**From:** Katie Kurek [redacted]  
**Sent:** 04 January 2019 11:20  
**To:** Simon Davis <Simon.Davis@arun.gov.uk>  
**Subject:** RE: WSCC Planning Consultations on AL/116/18/PL and AL/117/18/PL

**Subject:** WSCC Planning Consultations on AL/116/18/PL and AL/117/18/PL

I write in relation to the further requests from WSCC in respect of filed plan SP01 Rev B. I attach the architect's amended version SP01 Rev D for yours/WSCC's consideration. As before, if accepted, this plan will need to replace the reference in the filed application to plan SP01 Rev B.

DATE 10/16		REV D	
DRAWING EW		SP01	
215818		DRAWING NUMBER	
C/No.		SCALE	
0/No.		1/500 @ A2	
PROPOSED SITE PLAN CHICHESTER LAND AT FONTWELL AVENUE SITE MR DUGGIN FOR SCANDIA-HUS BUSINESS PARK FELCOURT ROAD, FELCOURT, EAST GRINSTEAD, WEST SUSSEX, RH19 2LP : TEL 01342 838060 scandiahus

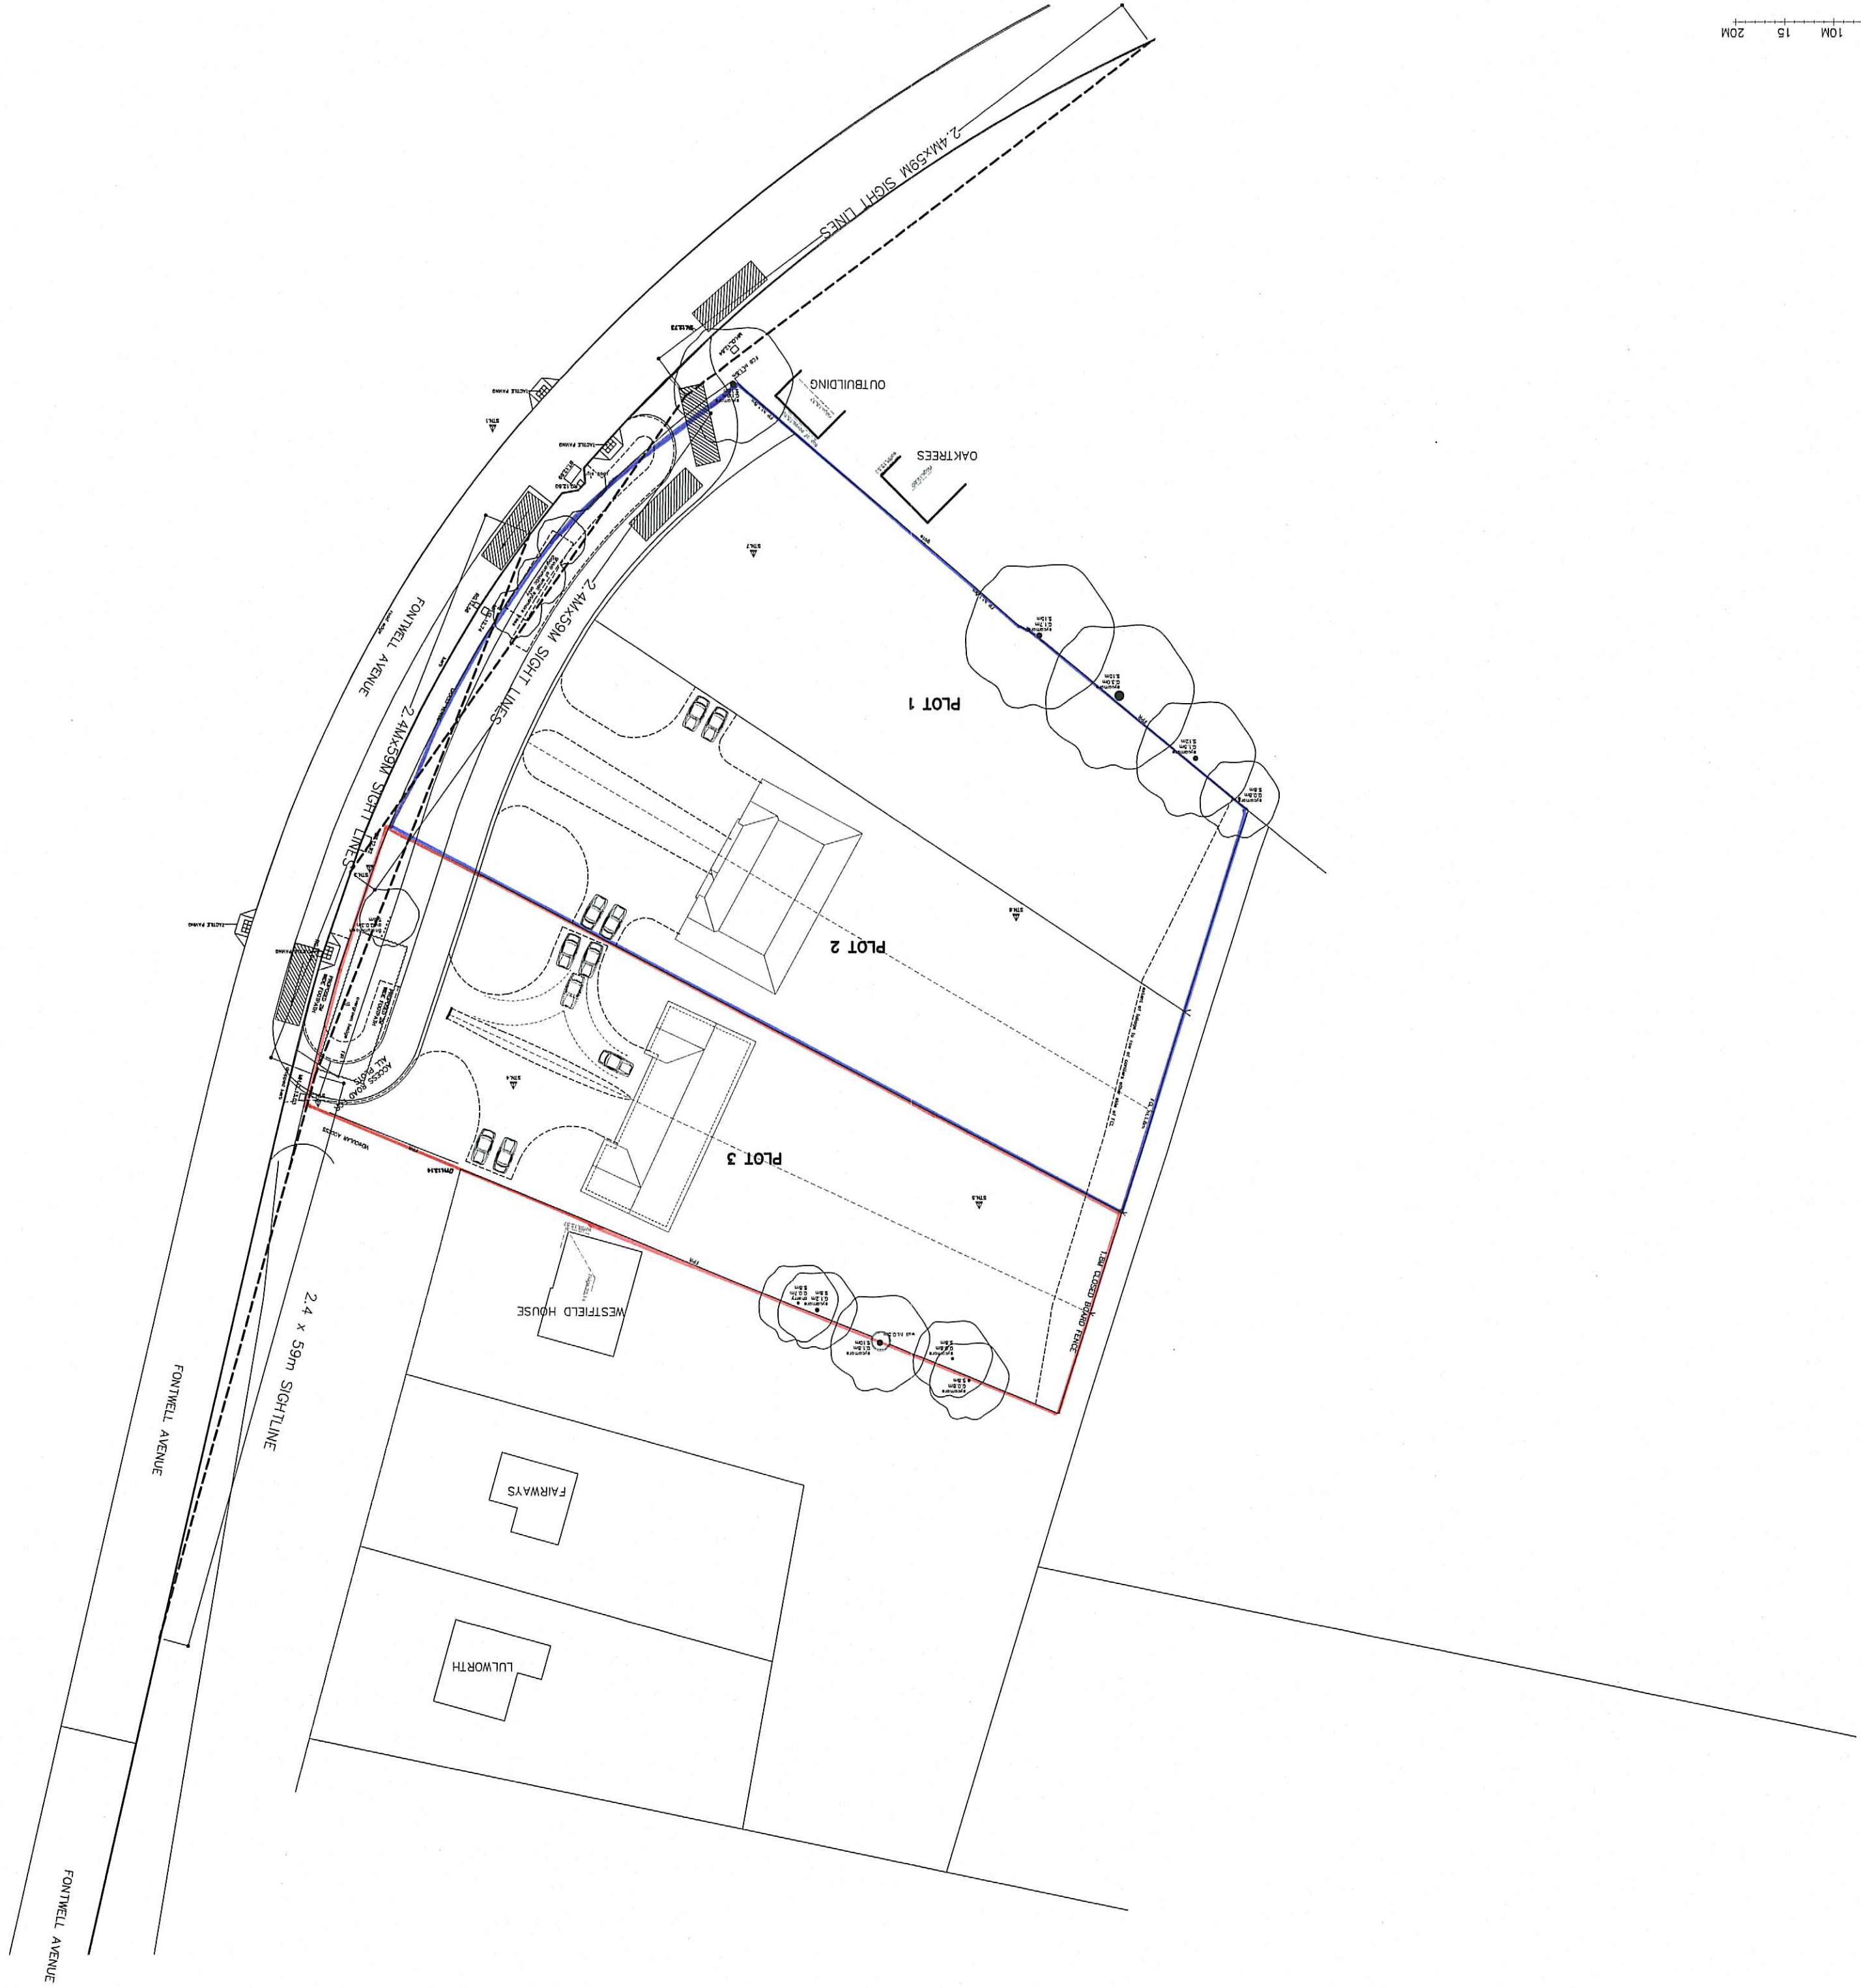
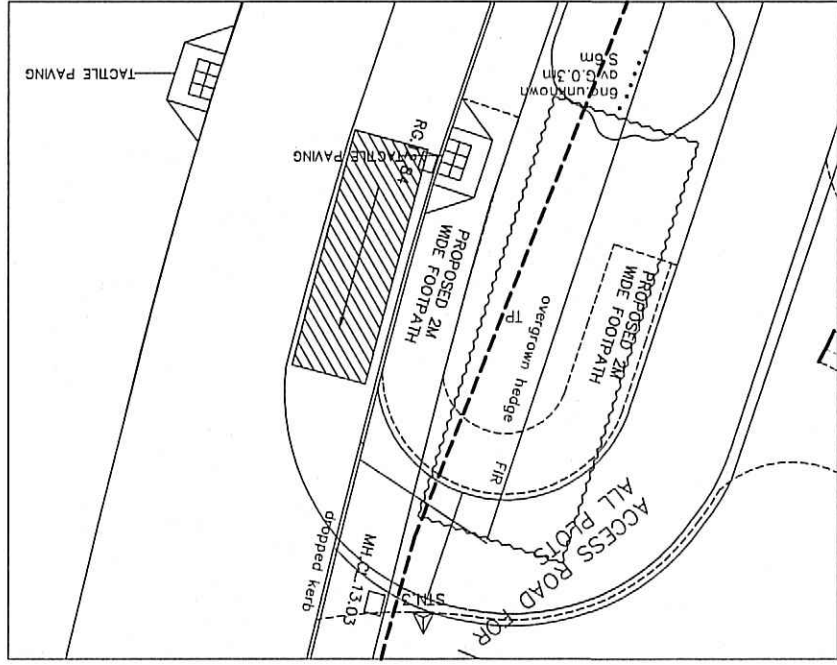
Provided that the splay shown passing through blue edged land can be maintained in perpetuity, the replacement with this plan is acceptable
